DECISION DELEGATED TO HEAD OF PLANNING

Application No:	H06-0231-26	Applicant:	Mrs K West
Proposal:	Proposed Change of Use of Existing Dog Walking Park to form domestic equestrian use, including Stables for Domestic Purposes		
Location:	Pegasus Dawsmere Road Gedney Drove End		
Terminal Date:	8th May 2026

TITLE: Plan and Elevations - As Proposed

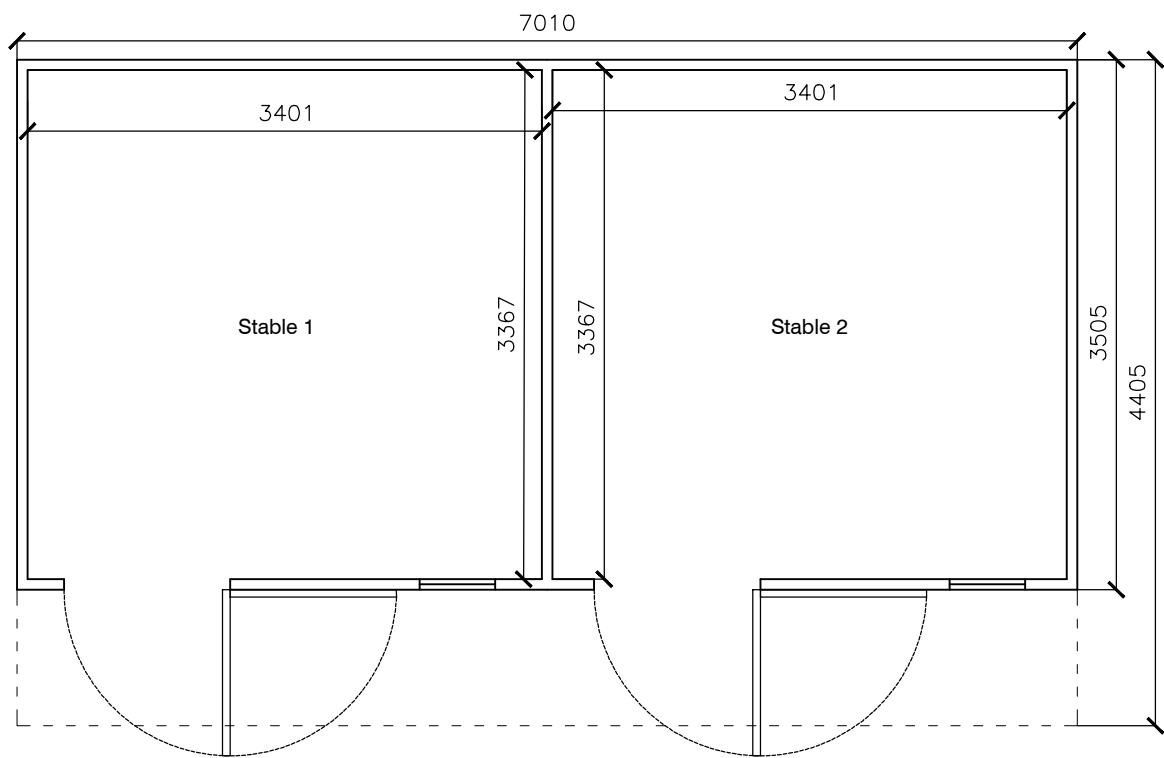
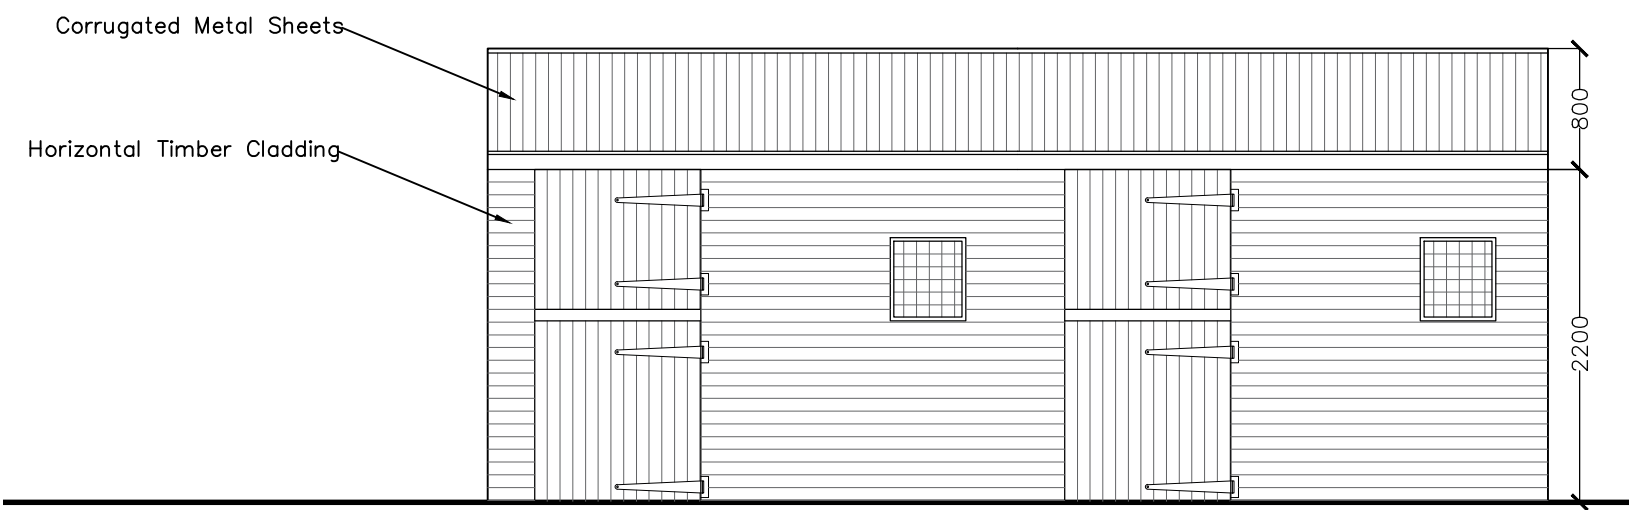
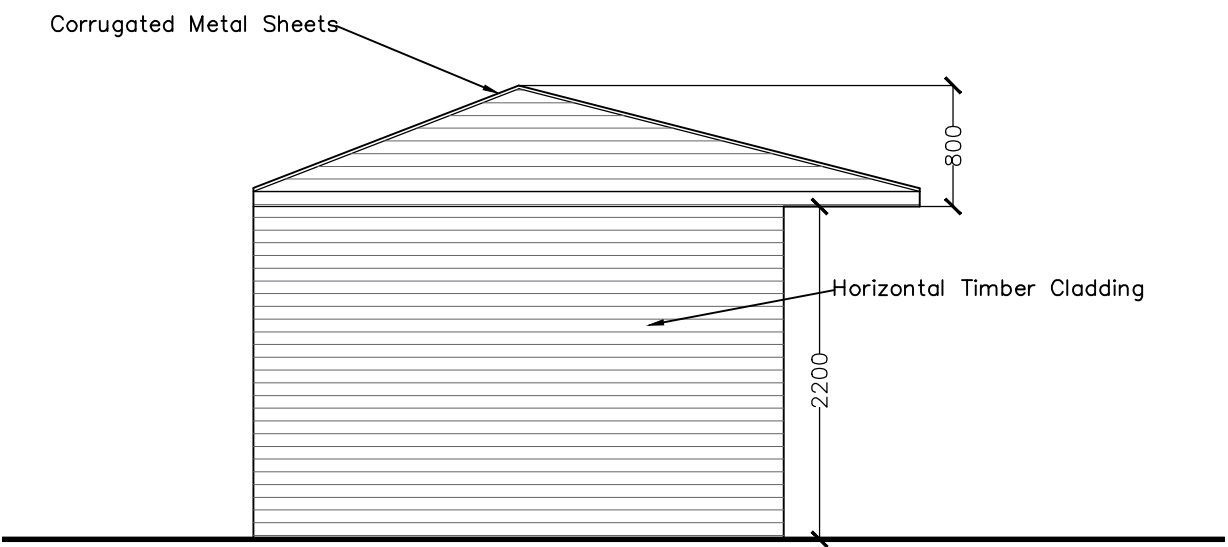
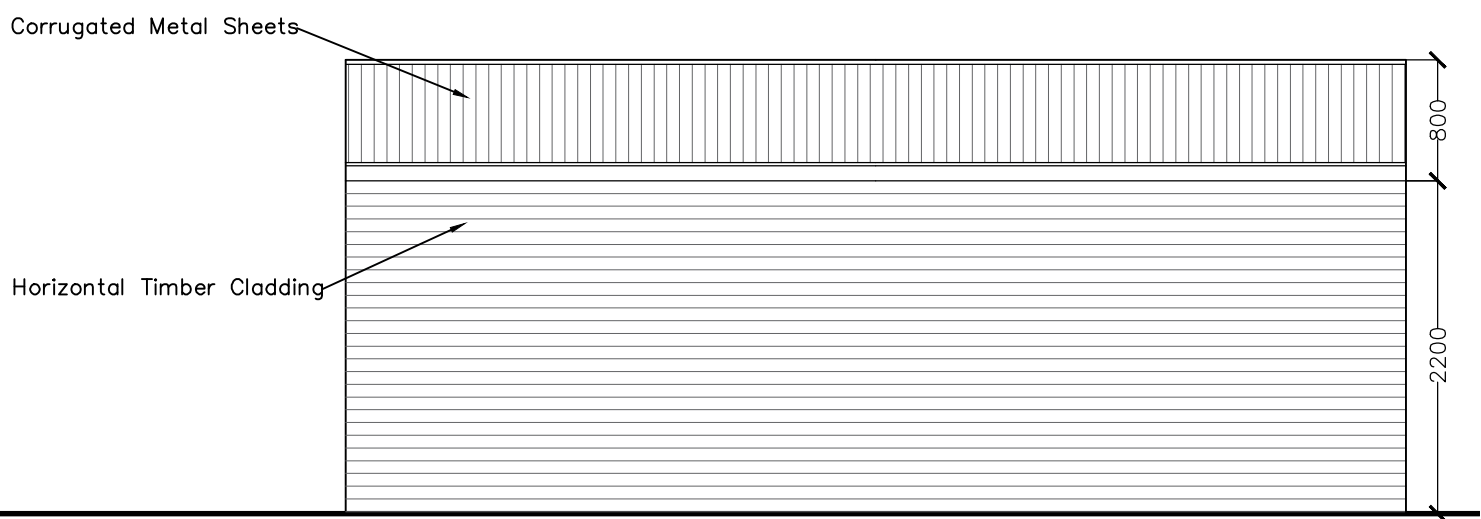
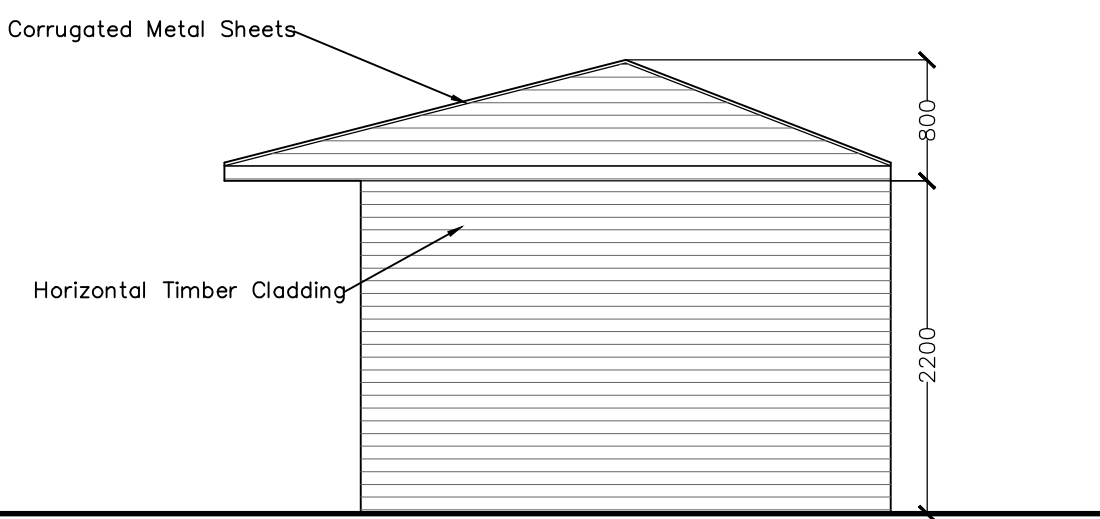
The stable block is proposed to be located near the south-eastern boundary of the site. This boundary adjoins Pegasus which is a residential dwelling. The stable block is proposed to measure 7m in length and 3.5m in width. The stable block is proposed to feature a pitched roof that would measure 2.9m in height up to its ridgeline. The building is proposed to feature timber cladding.

The stable building is likely to be largely screened from view along Dawsmere Road due to the position of dwellings within the street scene and hedging that is located around Pegasus. The dimensions of the building are similar to a typical outbuilding and overall, the visual impact of the building is considered to be acceptable.

The proposed stable block would also have an acceptable impact on the amenity of the nearest dwellings due to the minor nature of its scale and its positioning.

Proposed Block Plan
SCALE 1:500

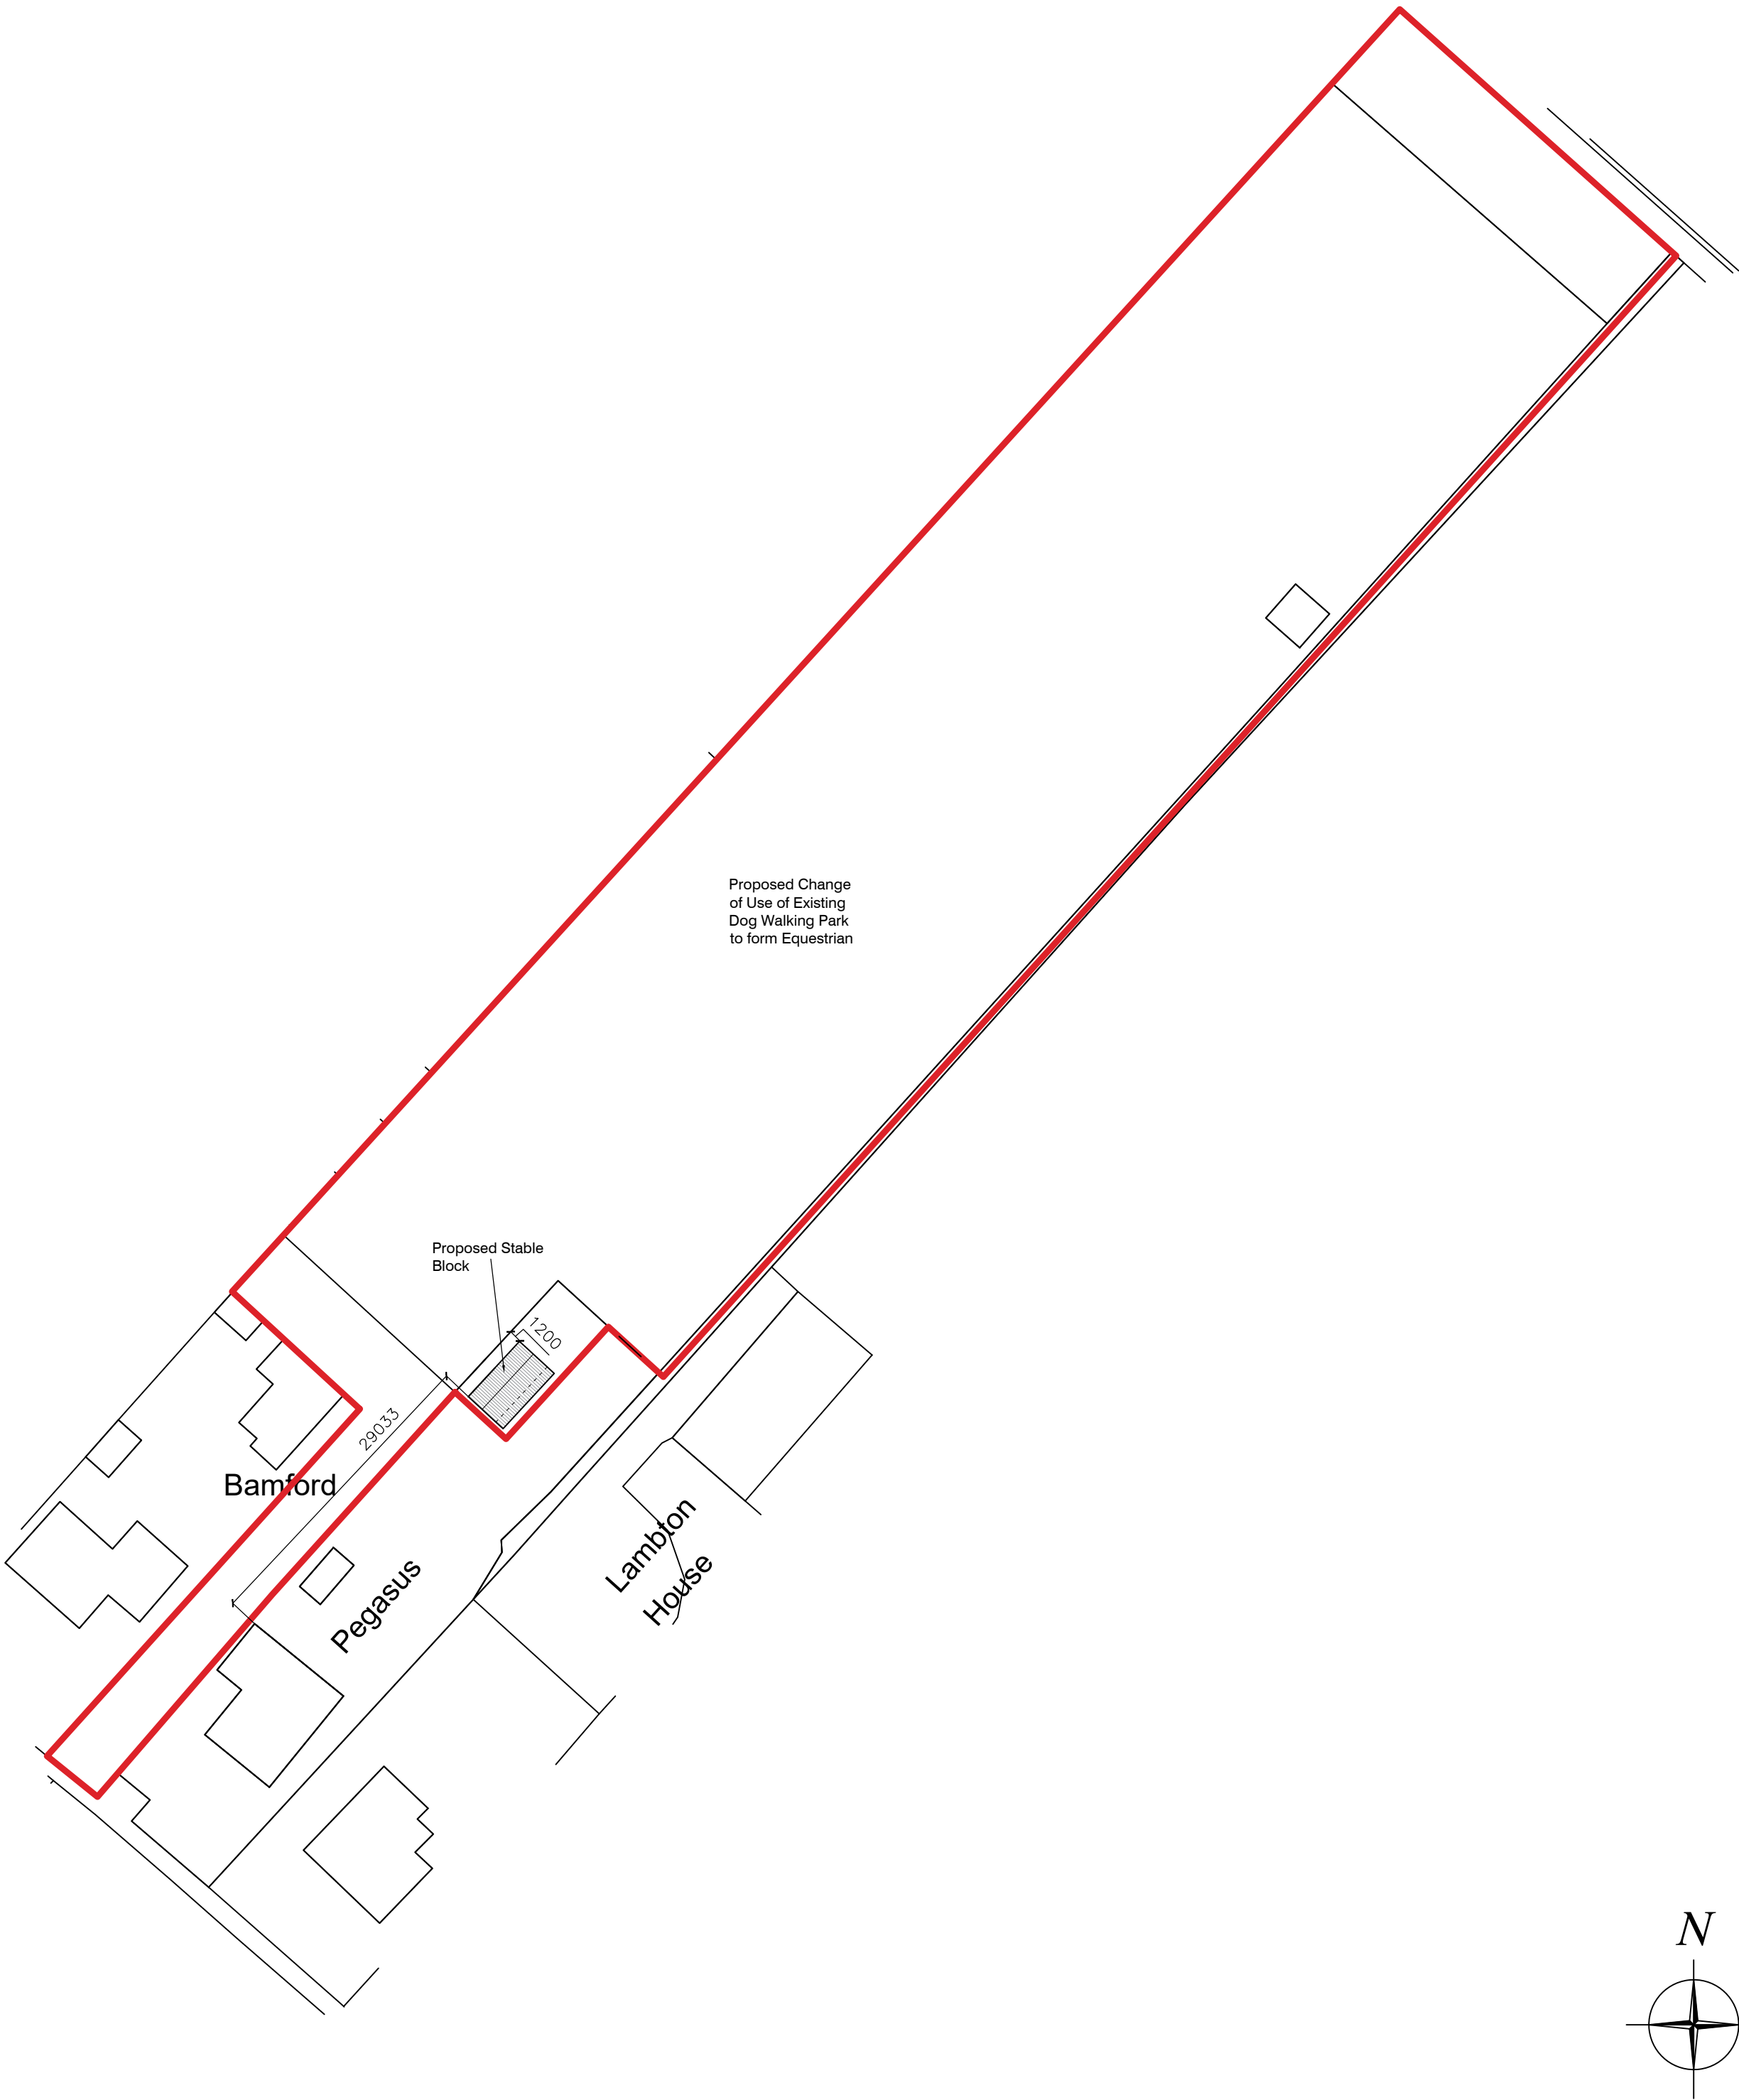
Consent is also sought for the erection of a stable block near the south-eastern boundary of the site. This boundary adjoins Pegasus which is a residential dwelling. The stable block is proposed to measure 7m in length and 3.5m in width. The stable block is proposed to feature a pitched roof that would measure 2.9m in height up to its ridgeline.

The boundary treatments around the site will remain unchanged. There is 1.9m high wire and mesh fencing around the site and gates near the access. As no changes are proposed, it is not considered necessary to secure further details via a condition.
